DOOLEY'S LIDCOMBE CATHOLIC CLUB - SSD 7603

COMMENTS FROM CUMBERLAND COUNCIL

Thank you for the opportunity to comment on the Concept Proposal for Tourist Related Purposes and Detailed Proposal for early works at Dooleys Lidcombe Catholic Club, Lidcombe, SSD 7603.

1 GFA - B02
1 : 750

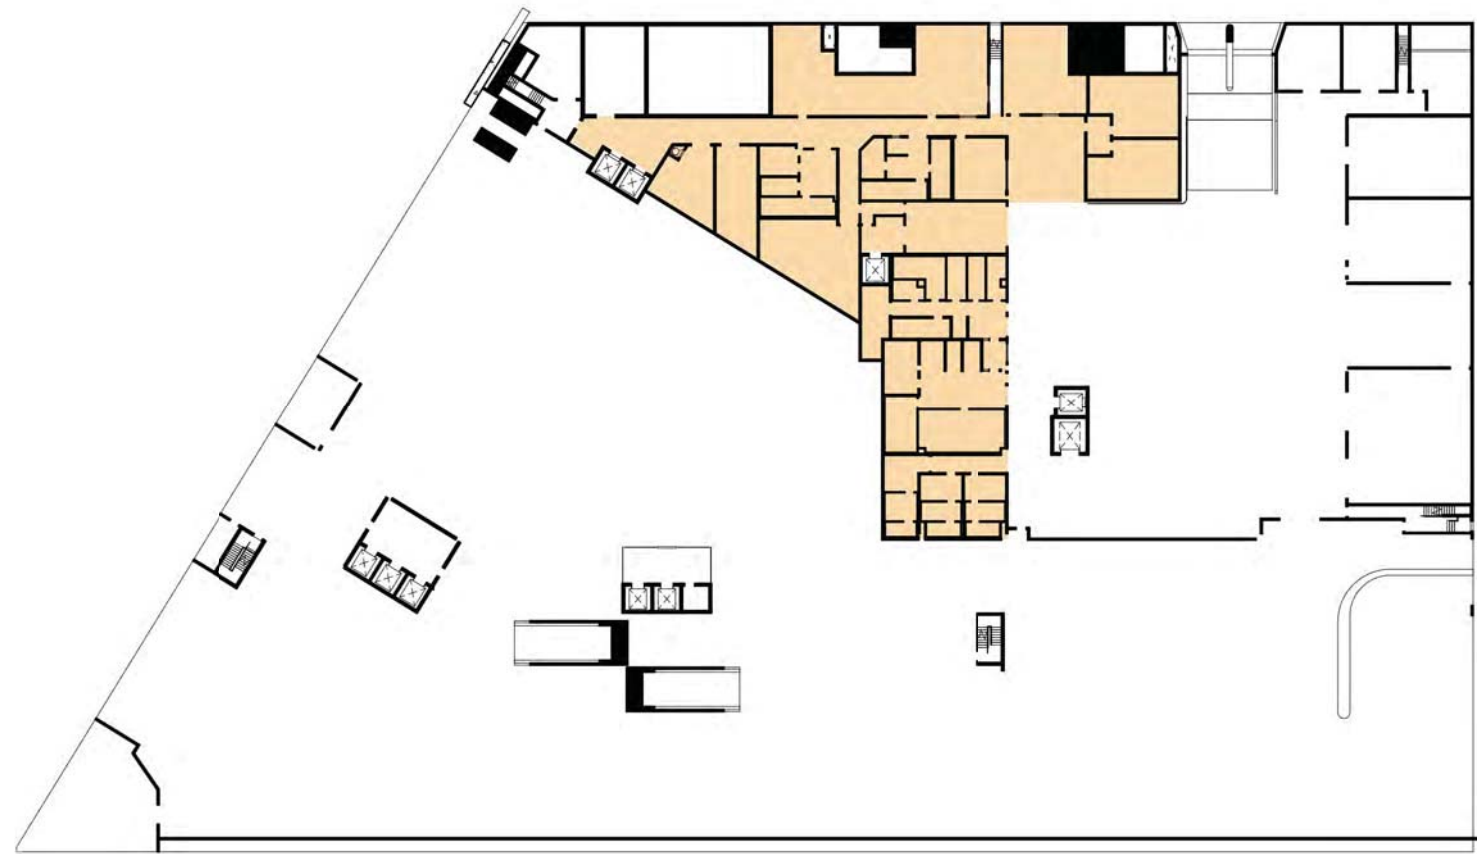
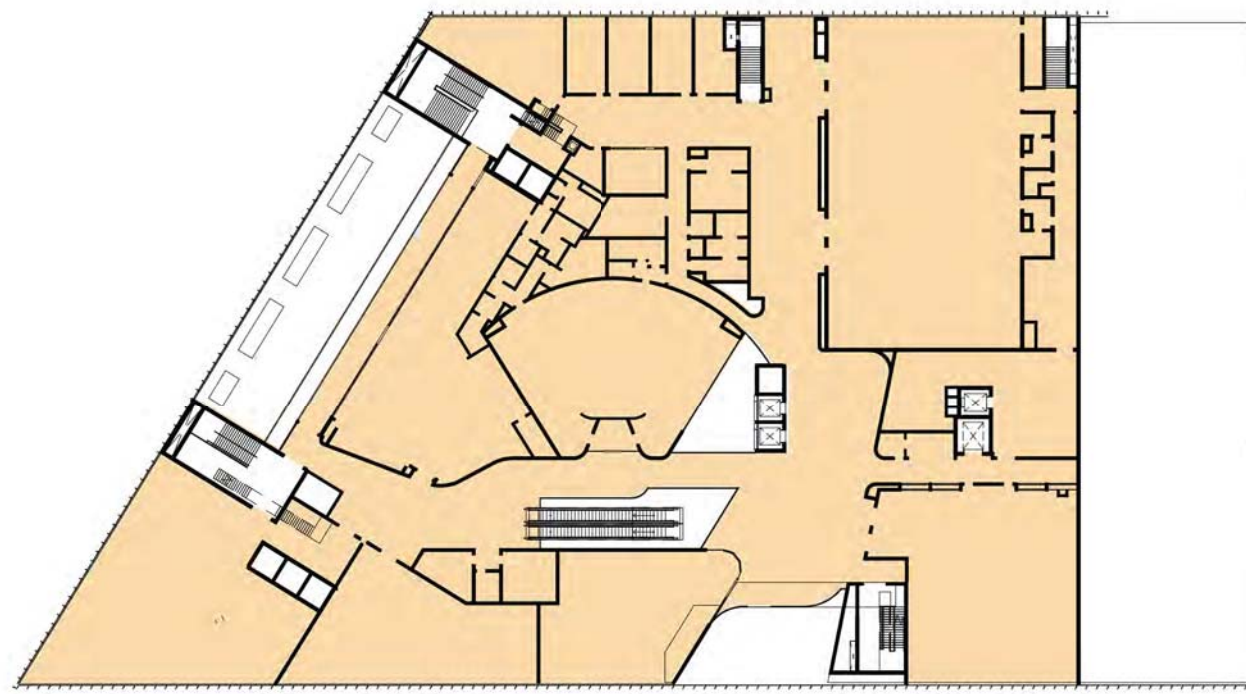
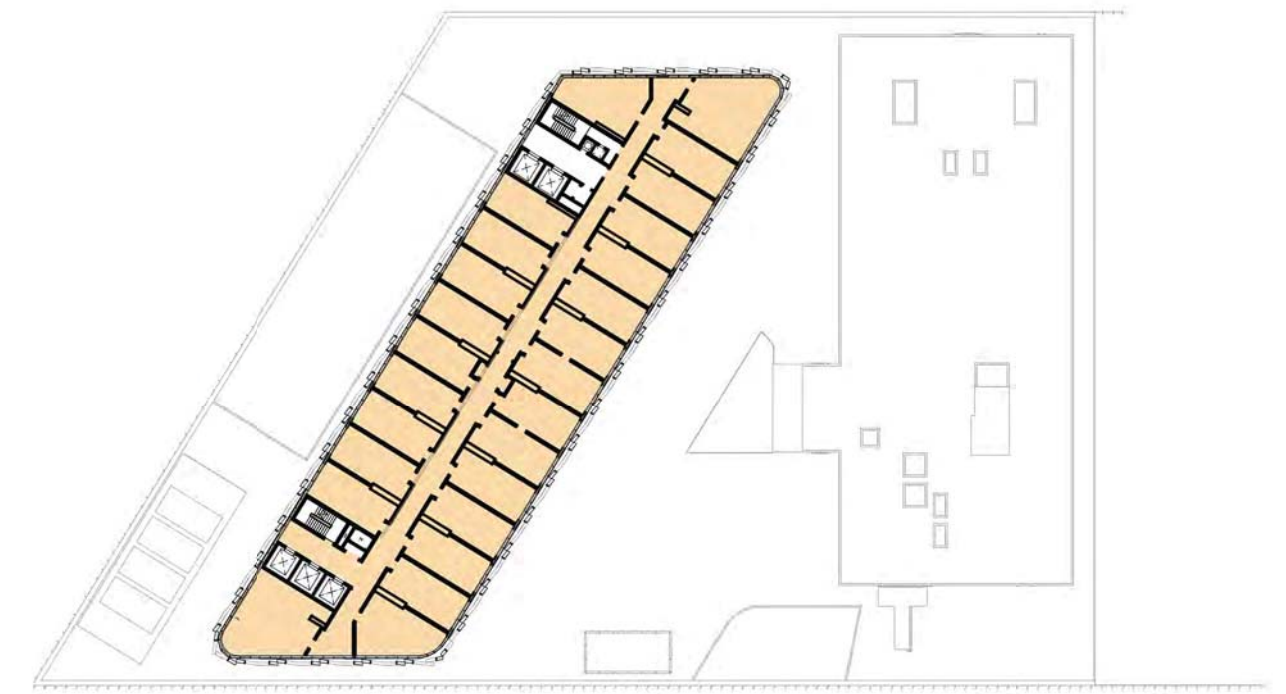
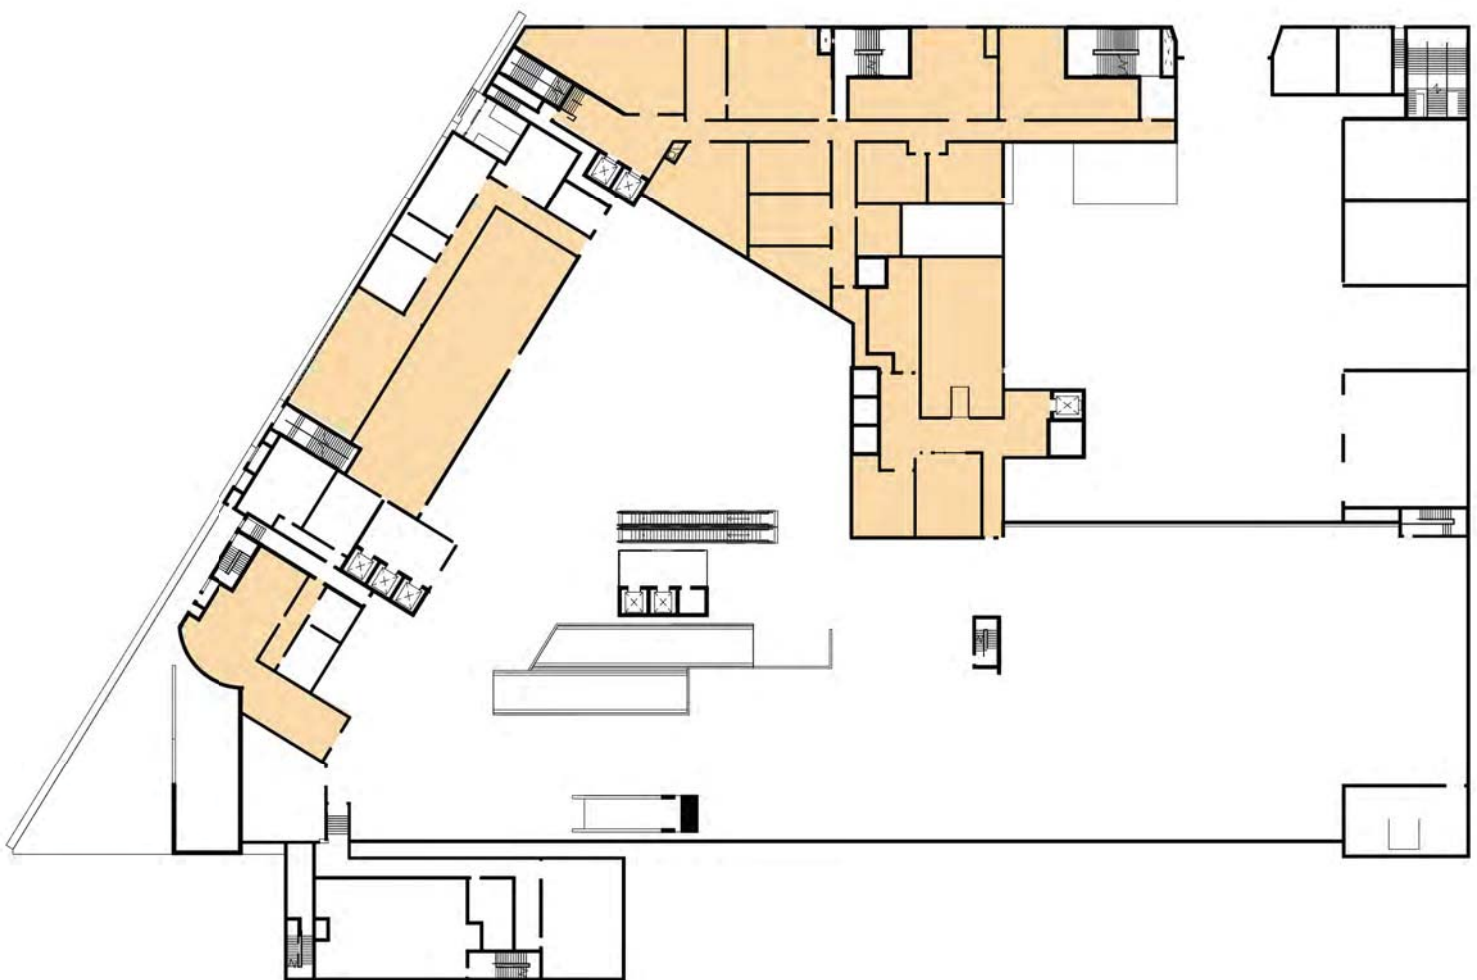
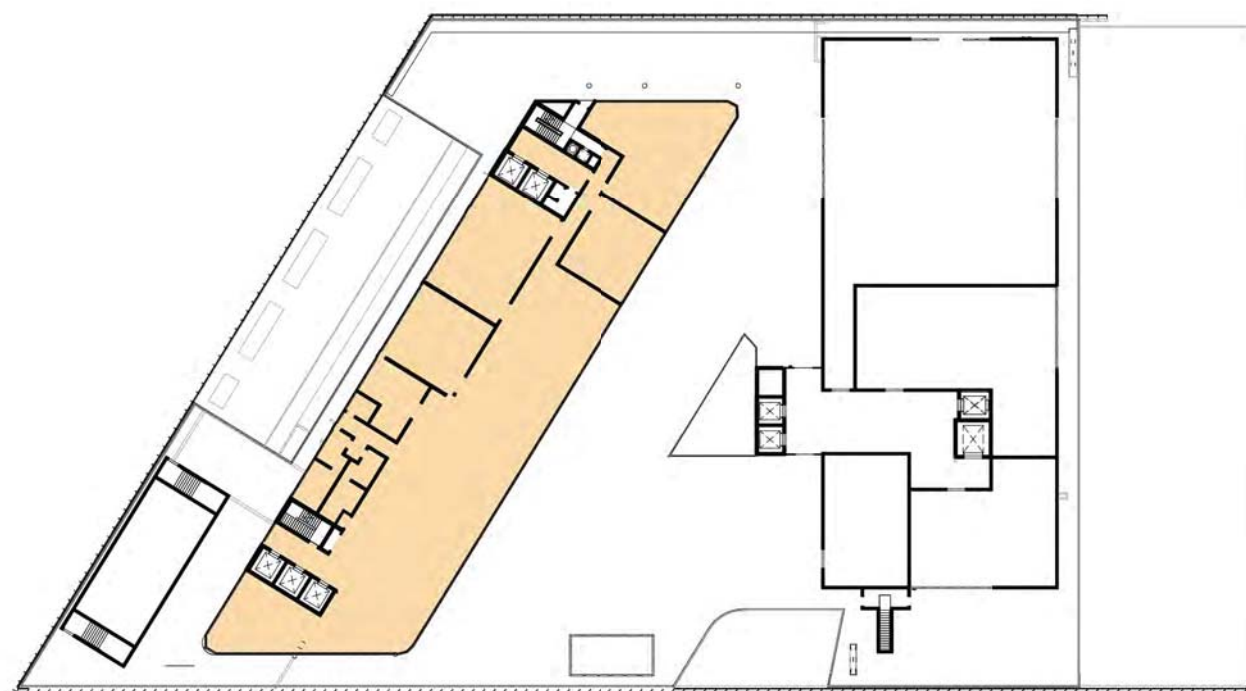
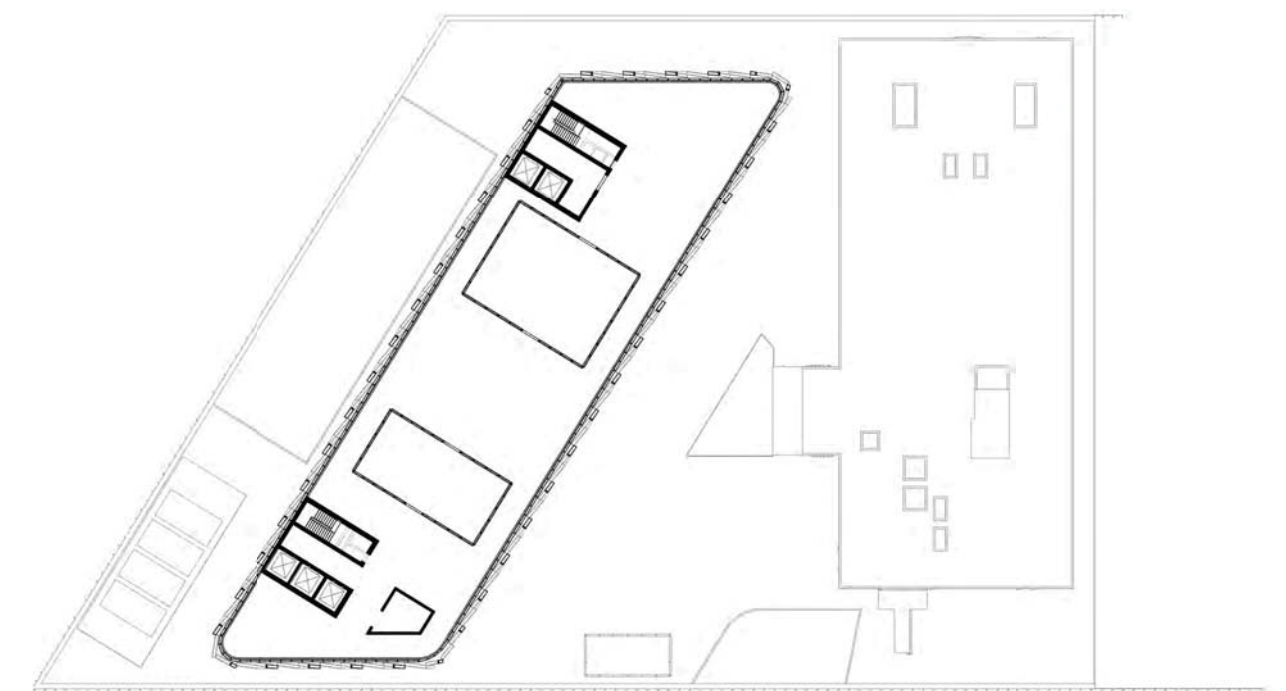
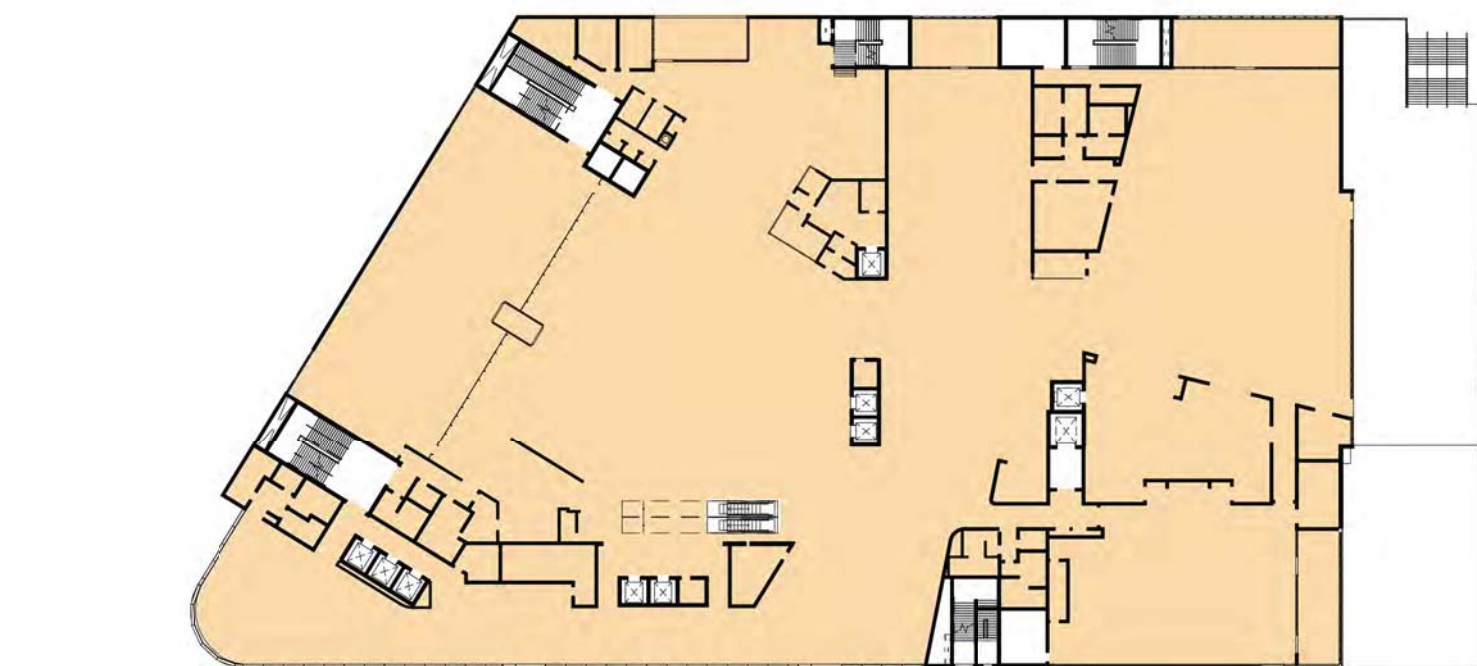
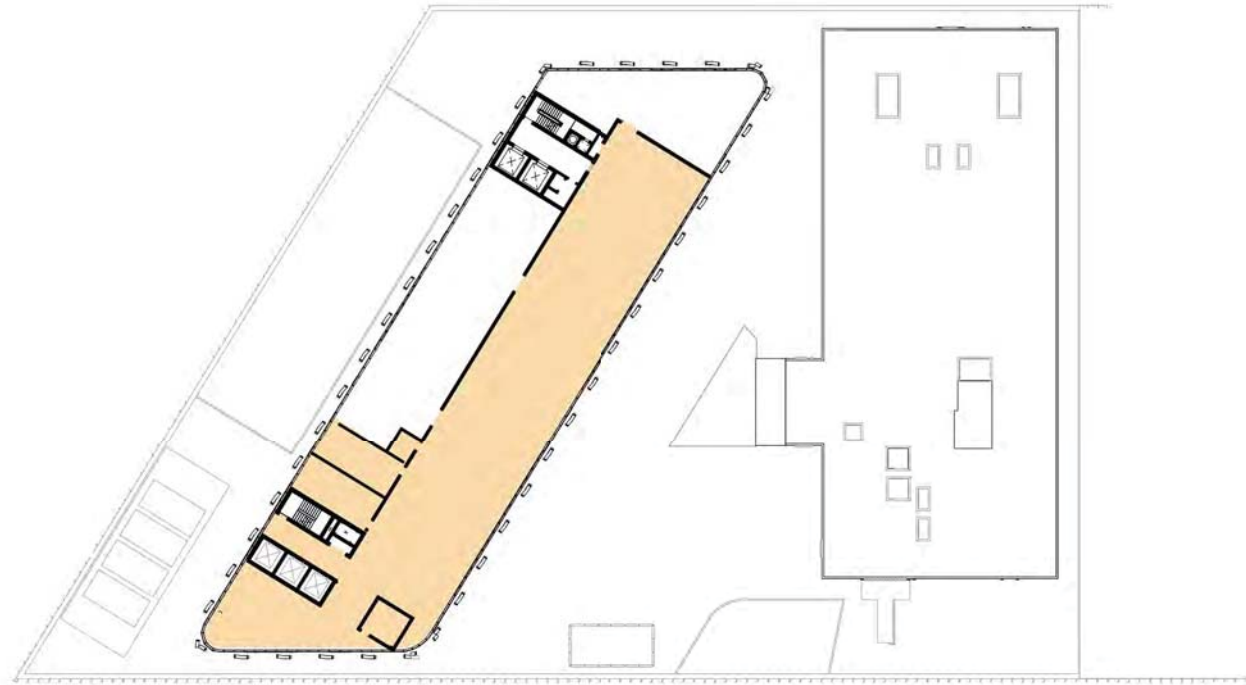
- h. The stated FSR of 1.23:1 is inaccurate as shown in tables 2 and 3 below, as 10 of the hotel levels are calculated as if they are only one level.

The 'site area' calculations include the existing club site, which is not part of the first stage of the development. Therefore, the potential FSR can be substantially higher following the completion of both phases of development. A re-estimate of the site area for the club/hotel complex based on more appropriate site boundaries (as outlined in yellow on Figure 1 below) would be approximately 9,960m².

The resulting FSR would be approximately 2.73:1 (ie 27,178m² / 9,960m²).
